Application for Planning Permission for Works or Extension to a Dwelling

Development: Erection of single storey rear extension.
Location: 11 Little Paddocks Ferring BN12 5NJ

SITE PLAN 1:500 @ A1

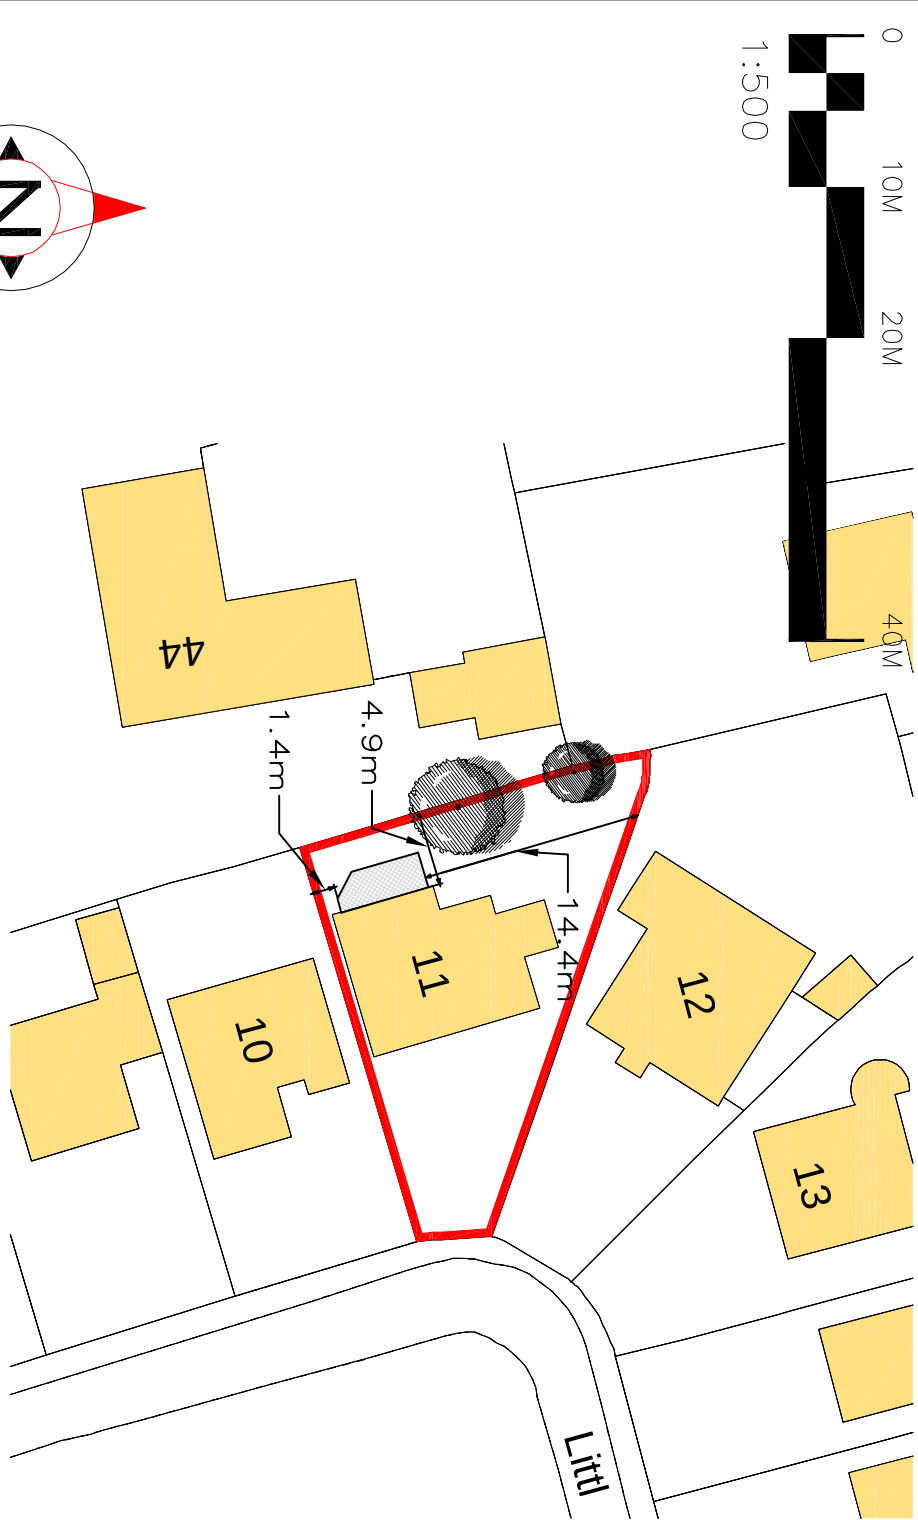
Block Plan

You are required to have dimensions from the proposed extension(s) to all site boundaries. Please amend.

Existing Floor Plan

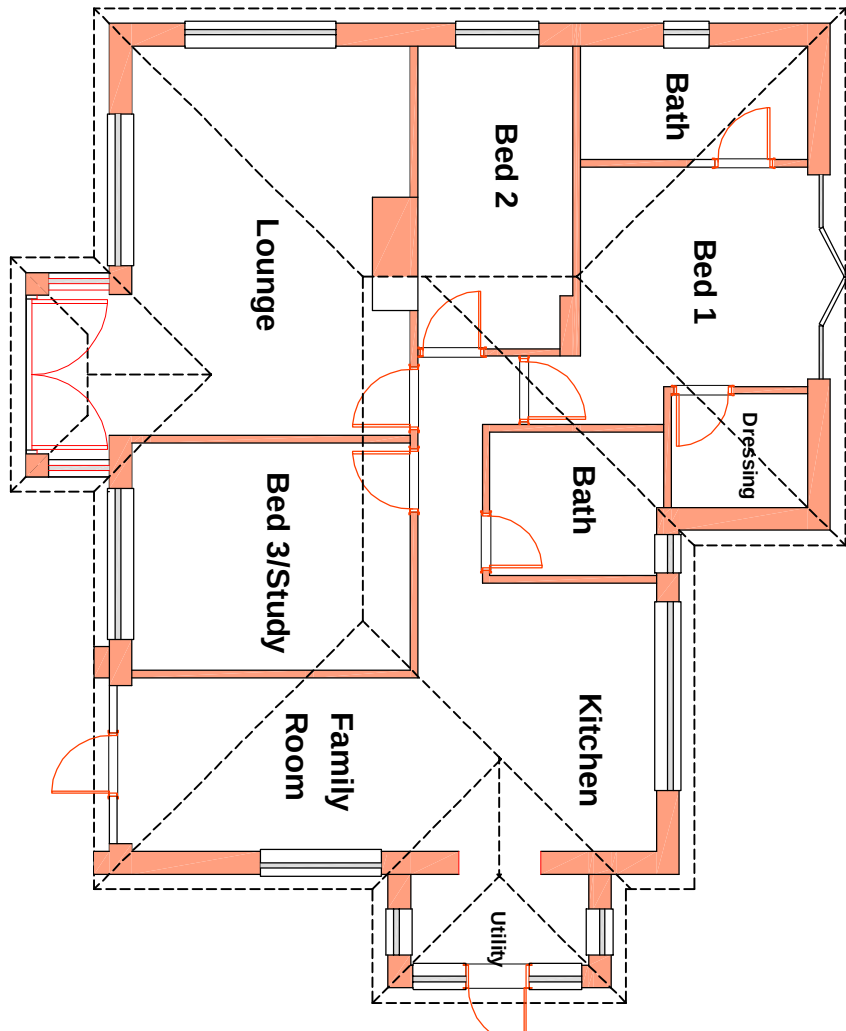
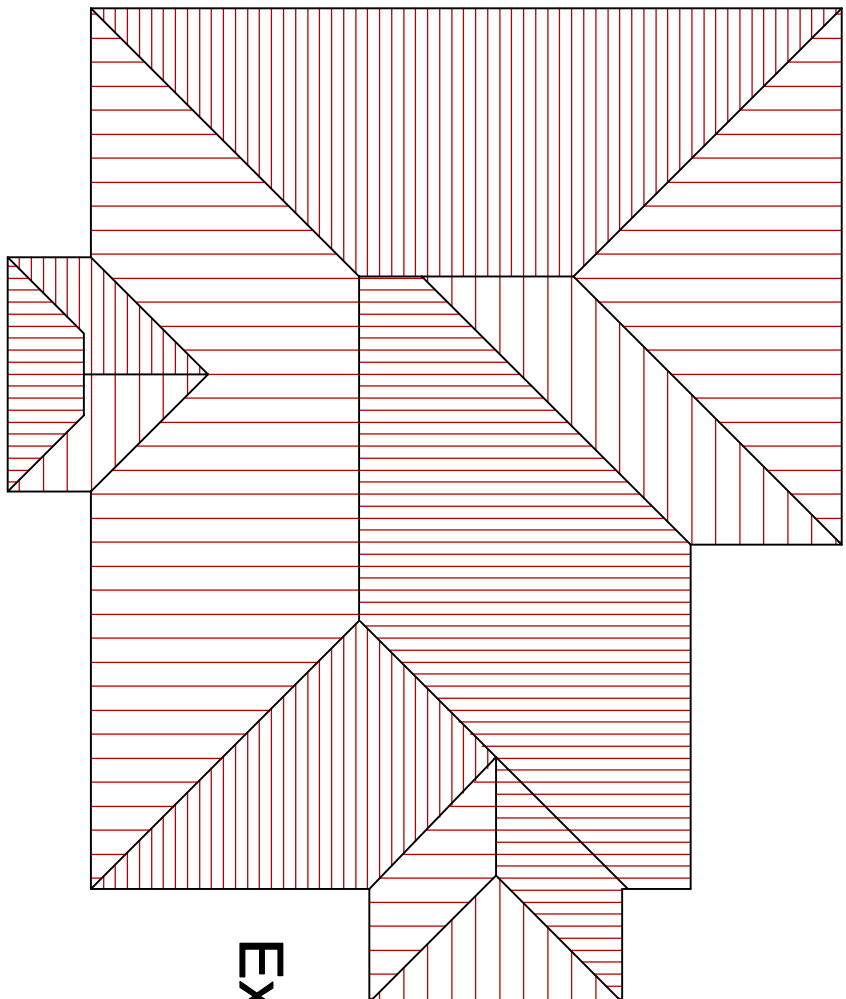
Inconsistent Plans

The utility room windows shown on the existing/proposed front, north west and rear elevations are missing from the existing/proposed floor plans. Please amend.
